**RE: ATLISSIAN CENTRAL
BCA/ACCESS/DDA COMPLIANCE STATEMENT FOR STATE SIGNIFICANT DEVELOPMENT
APPLICATION**

Blackett Maguire + Goldsmith Pty Ltd have been commissioned by Atlassian (the applicant) to prepare this report in accordance with the technical requirements of the secretary's Environmental Assessment Requirements (SEAR's) and in support of the SSD-10405 for a commercial and hotel development above the Former Inwards Parcel Shed at 8-10 Lee Street, Haymarket

GENERAL ARRANGEMENT
PLAN TOWER LEVEL 38

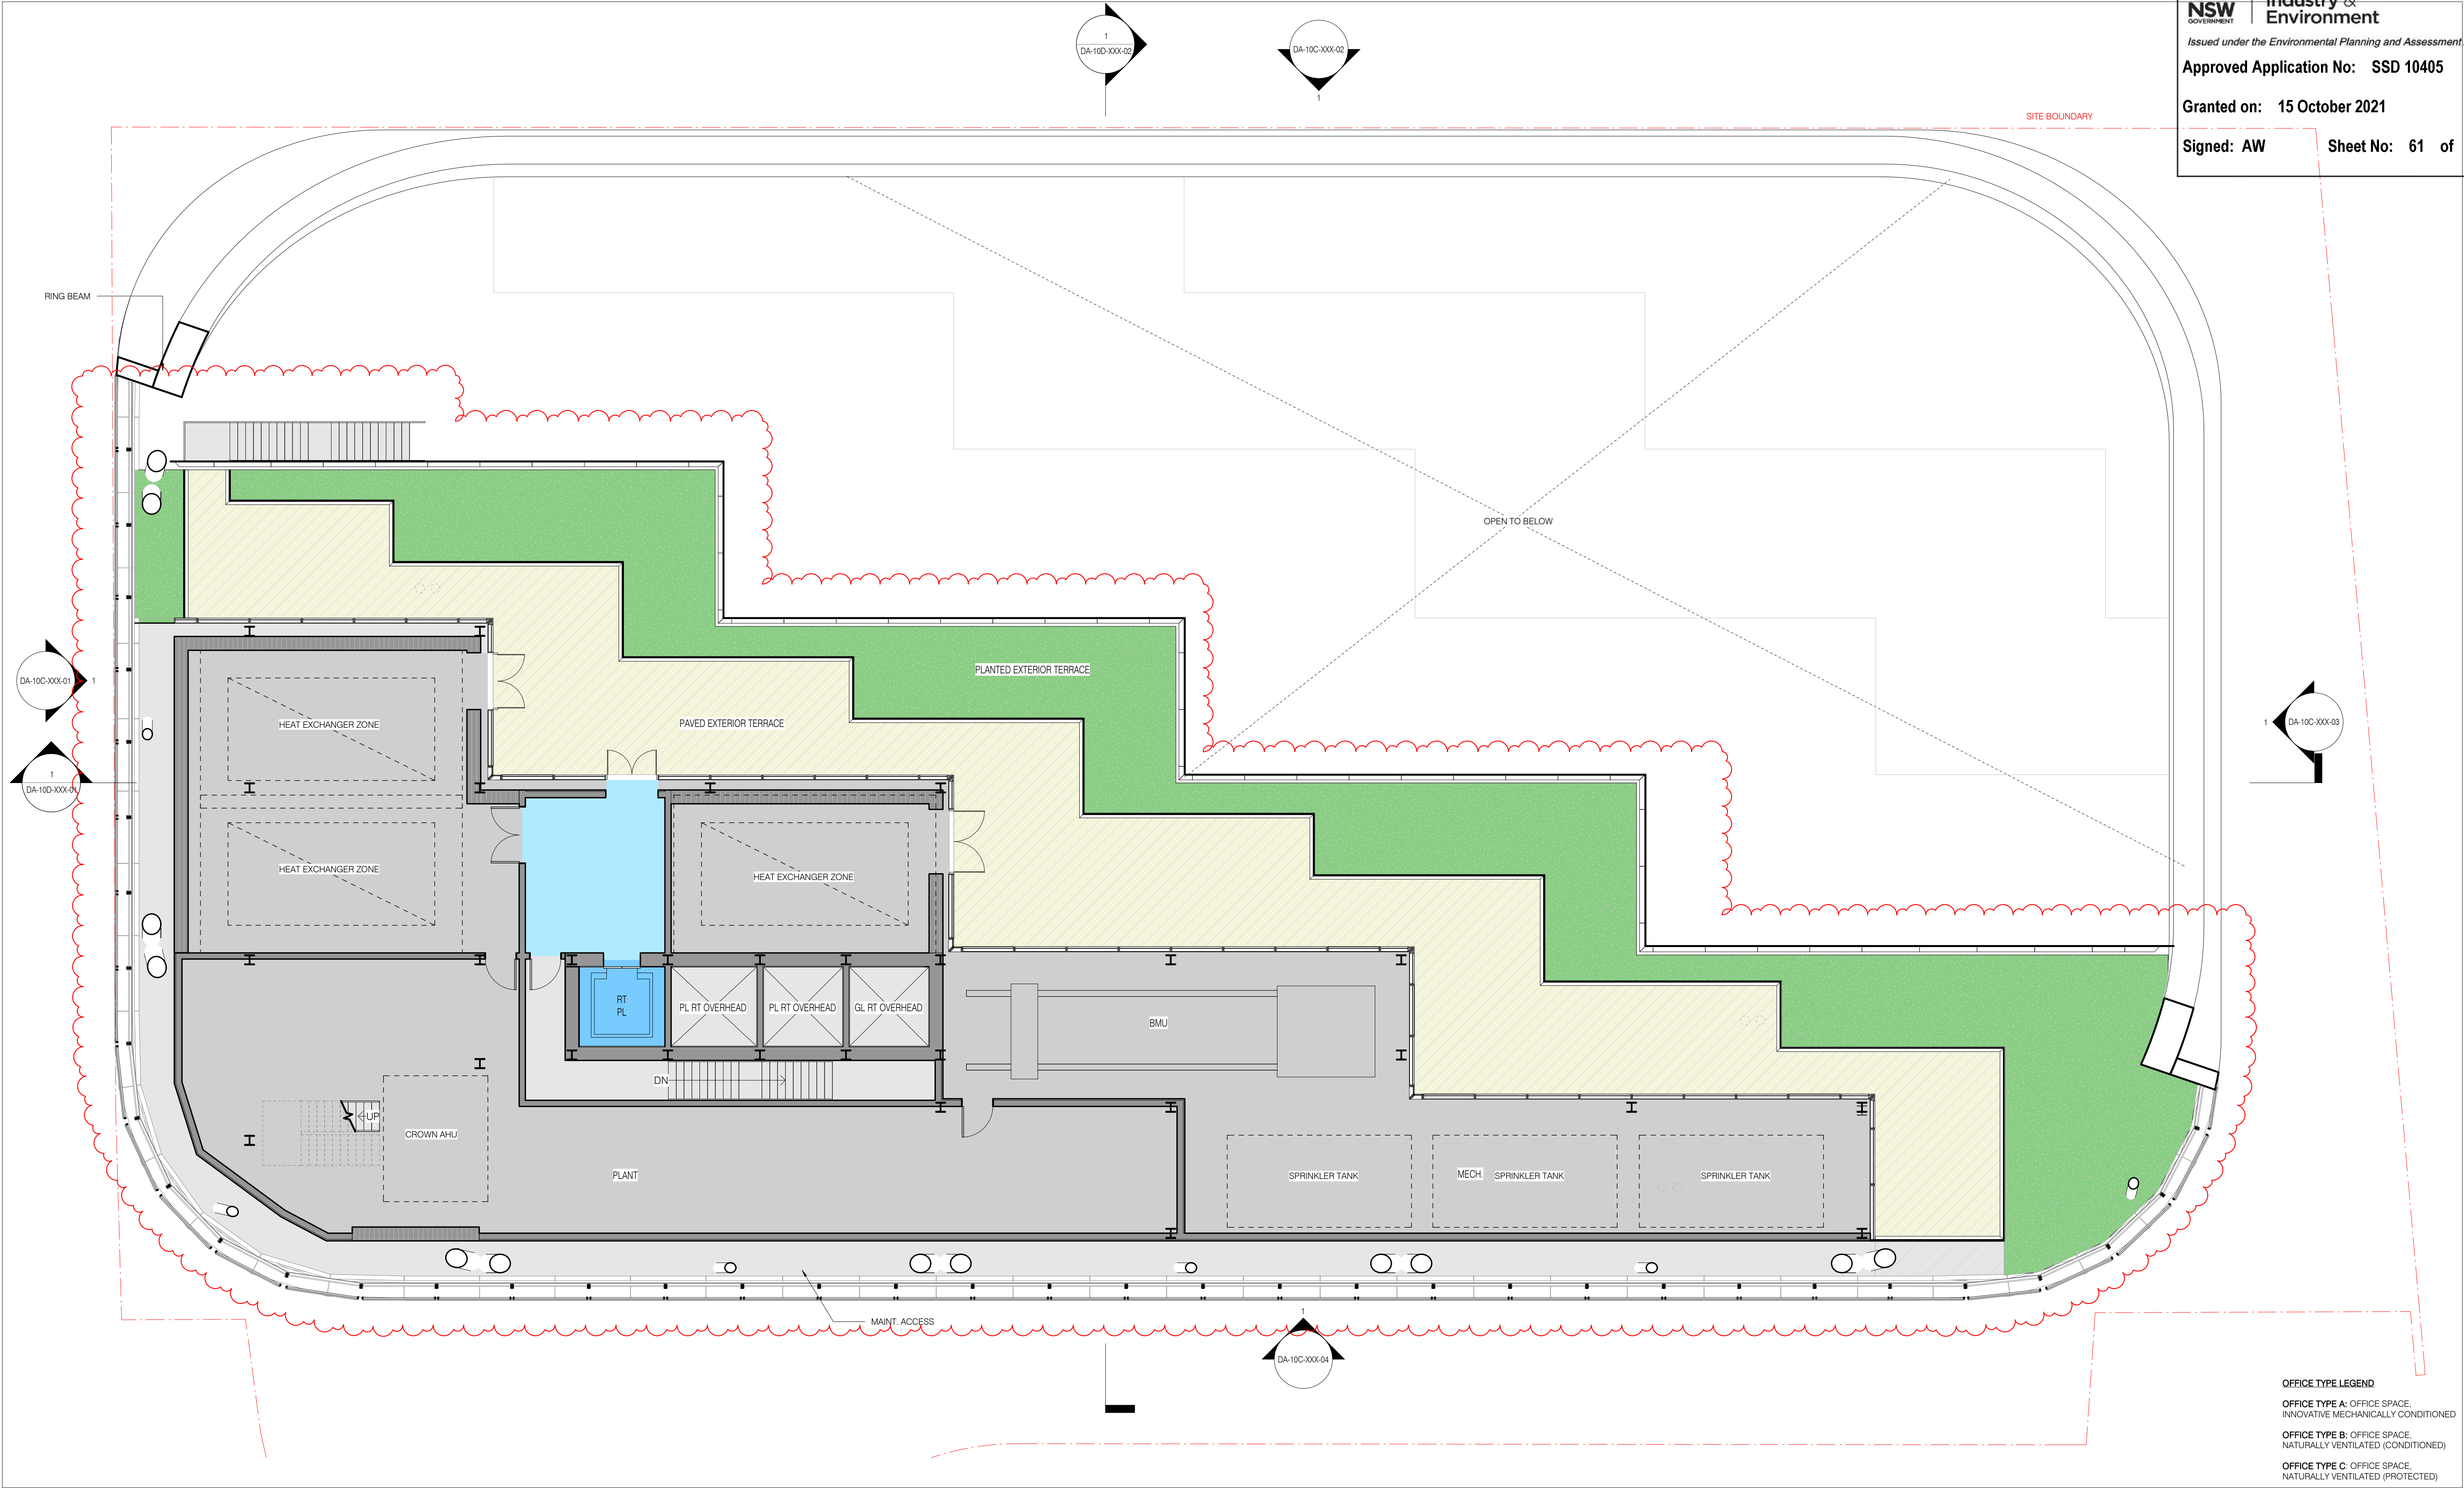
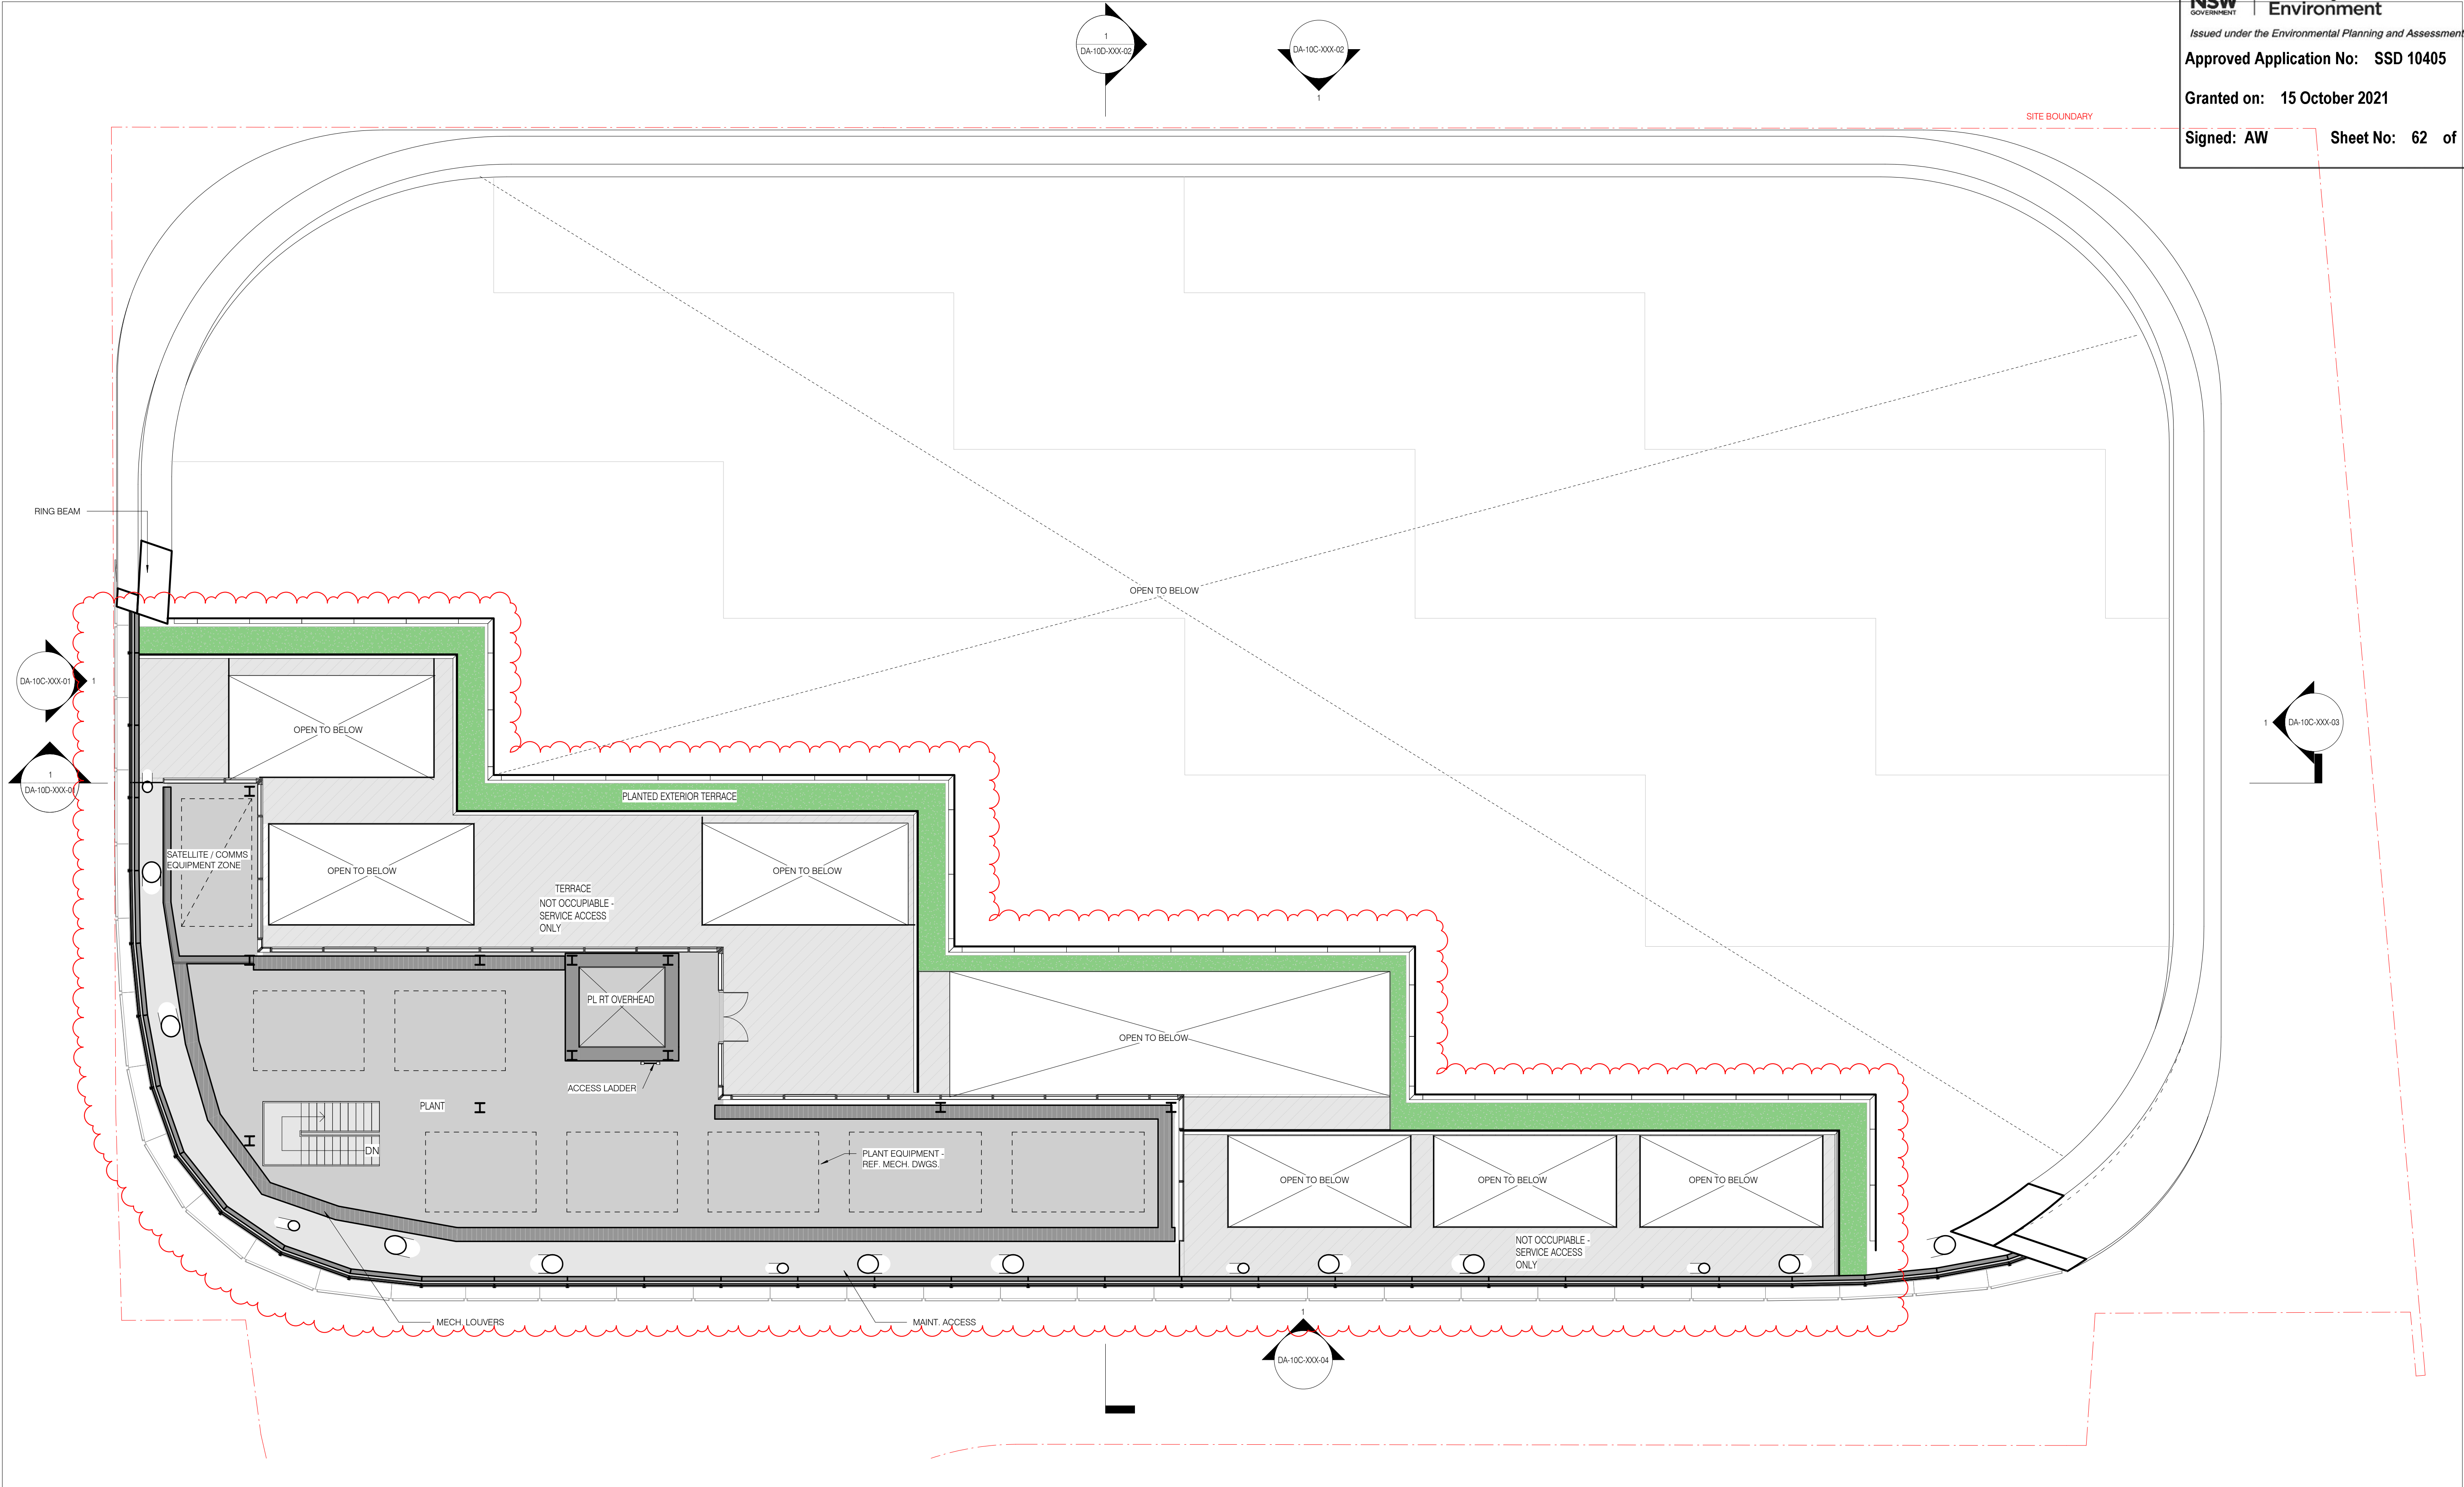
| 7. | D1.2 | <p>Only one exit is provided to the following areas in a building over 25m;</p> <ul style="list-style-type: none"> + Lower ground retail tenancies + Level 38 and 39 Plant rooms. |
| 8. | D1.3 | To have a non-fire isolated exit in lieu of a fire isolated exit serve and connect level 37-39 plant room areas. |
| 9. | D1.4 | <p>Exit travel distances in the order of; <i>(to be refined)</i></p> <ul style="list-style-type: none"> + Class 5,7,8 BOH basement areas: 28m to point of choice in lieu of 20m. + Class 3 Level 6: 12m to point of choice in lieu of 6m. + Class 5 office levels: 28m to point of choice in lieu of 20m + Class 5 office levels: 60m to nearest exit in lieu of 40m. + Class 5 ancillary plant areas level 37-39: 40m to point of choice in lieu of 20. |
